Application for a Non-Material Amendment Following a Grant of Planning Permission

Development: Changes to certain materials/details , namely:-

Location: Mayflower Way Angmering BN16 4AY

Thank you for your application submitted via the internet on 1st June 2021. It has been downloaded and will be checked for validity by the Technical Support Unit. It has been allocated the reference number **A/111/21/NMA.**

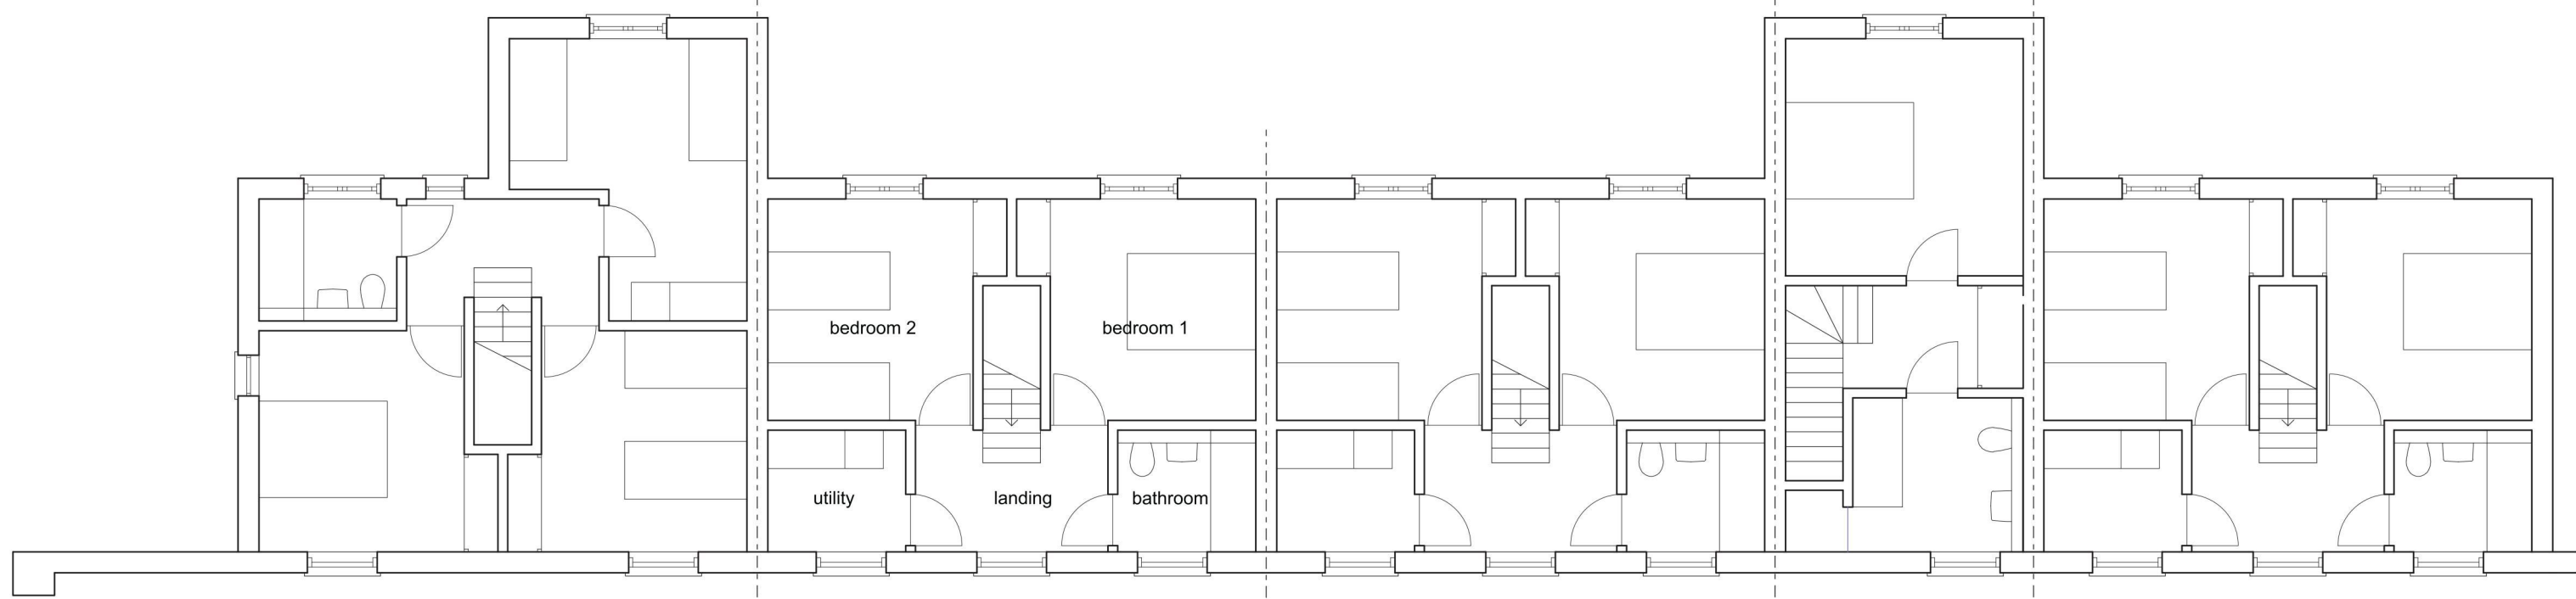
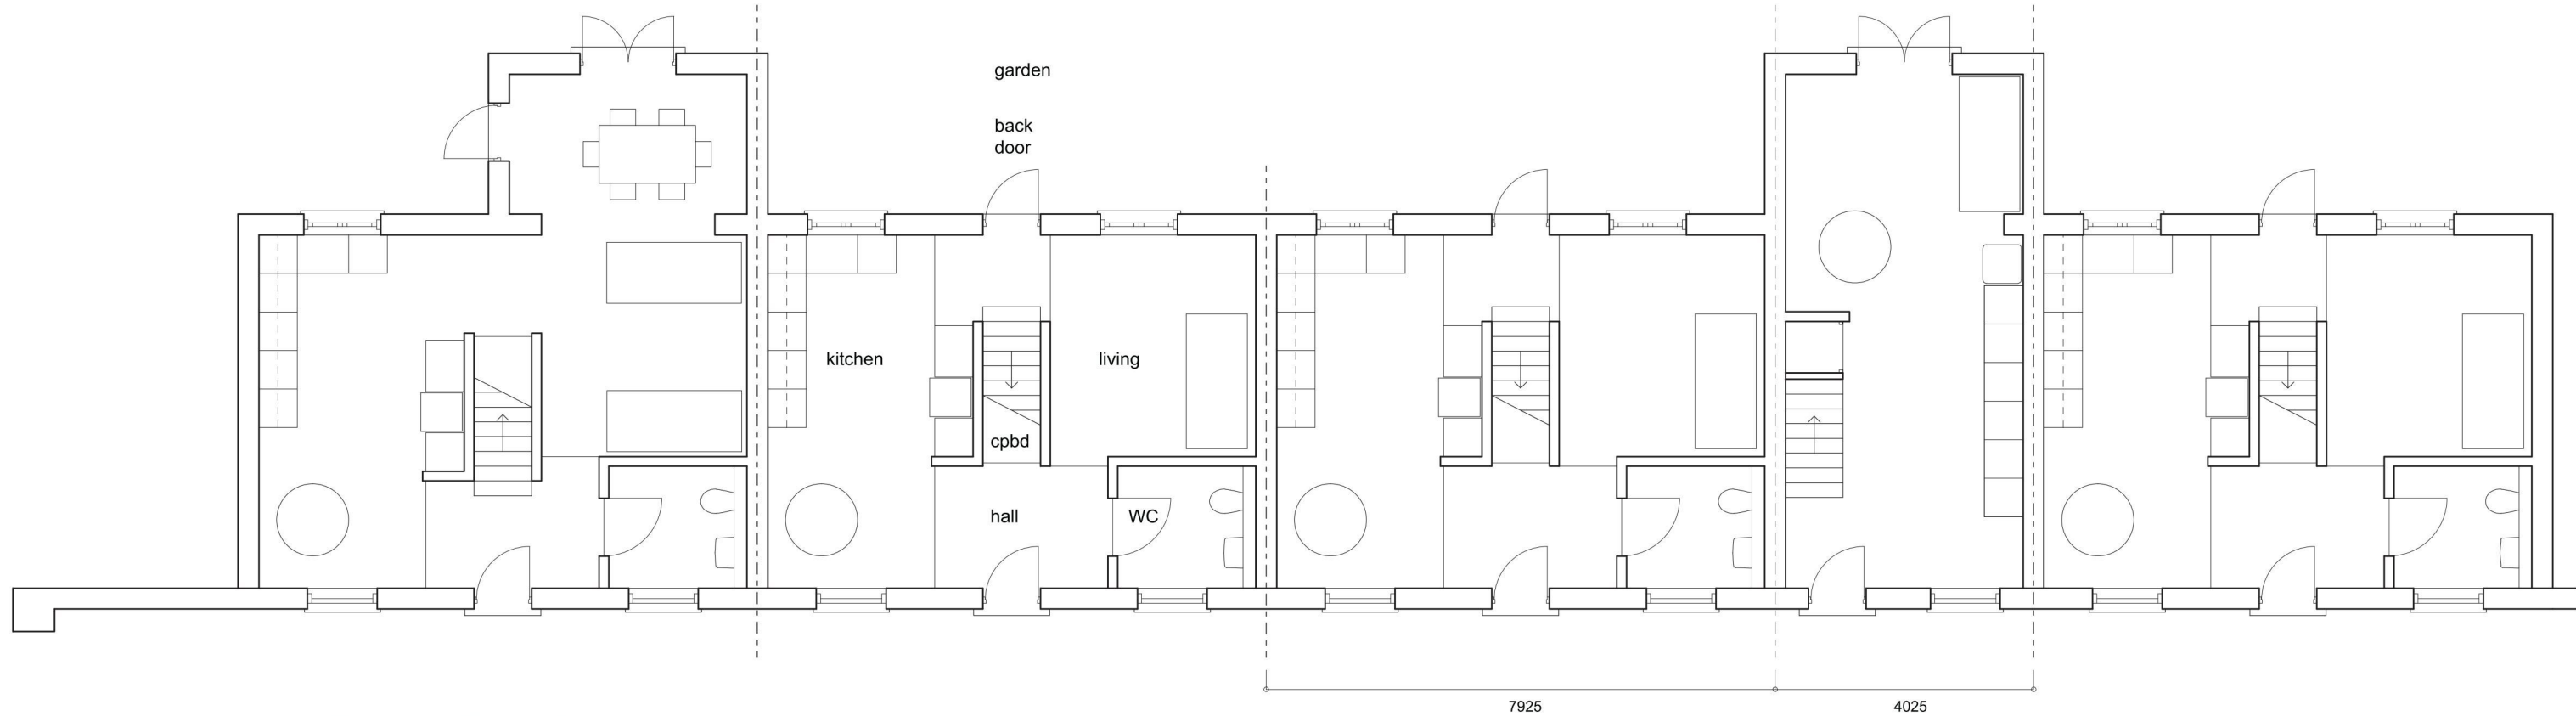
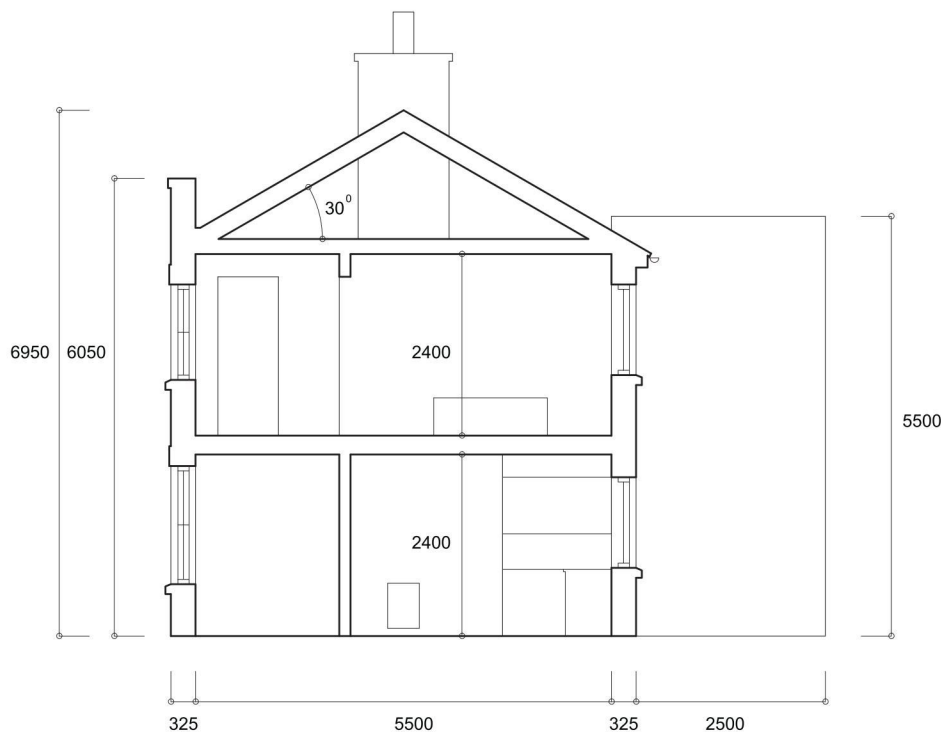
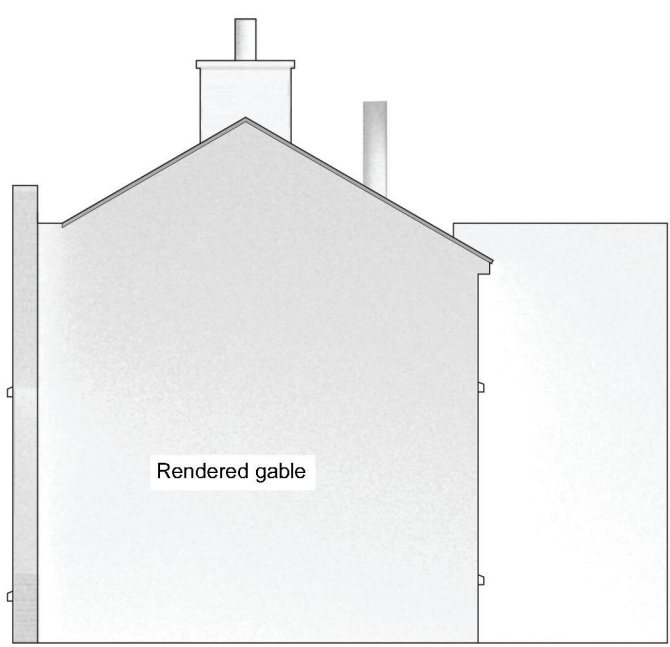
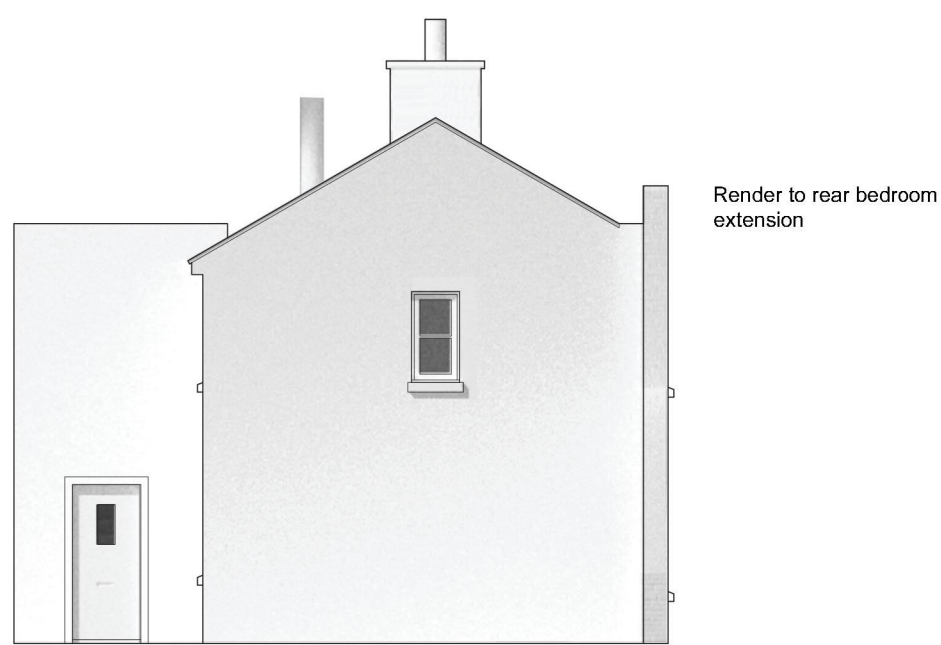
- 1 There is no gas supply to this site and wood burners are environmentally damaging. Given these facts then the chimneys/flues will not be working items. It is proposed to remove the galvanised steel flues however all chimneys will remain but non-functional, with traditional masonry flues (pots). Reason: Environmental considerations

- 2 Roof tiles shown as clay pantiles will be changed to concrete pantiles while providing the same overall appearance. Reason: Development costs
- 3 Roof tiles to be artificial Slate providing the same overall appearance. Reason: This is clarification of what was only stated at planning as slate. Development costs would direct us to artificial.

- 4 Rainwater goods to be black PVCu with cast Iron effect. Reason: Development cost and on-going burden of cyclical maintenance.
- 5 Windows to be PVCu White providing the same overall appearance Reason: Development cost and on-going burden of cyclical maintenance.

- 6 Front doors to be GRP composite PAS24 while providing the same overall appearance. Reason: Development cost and on-going burden of cyclical maintenance.
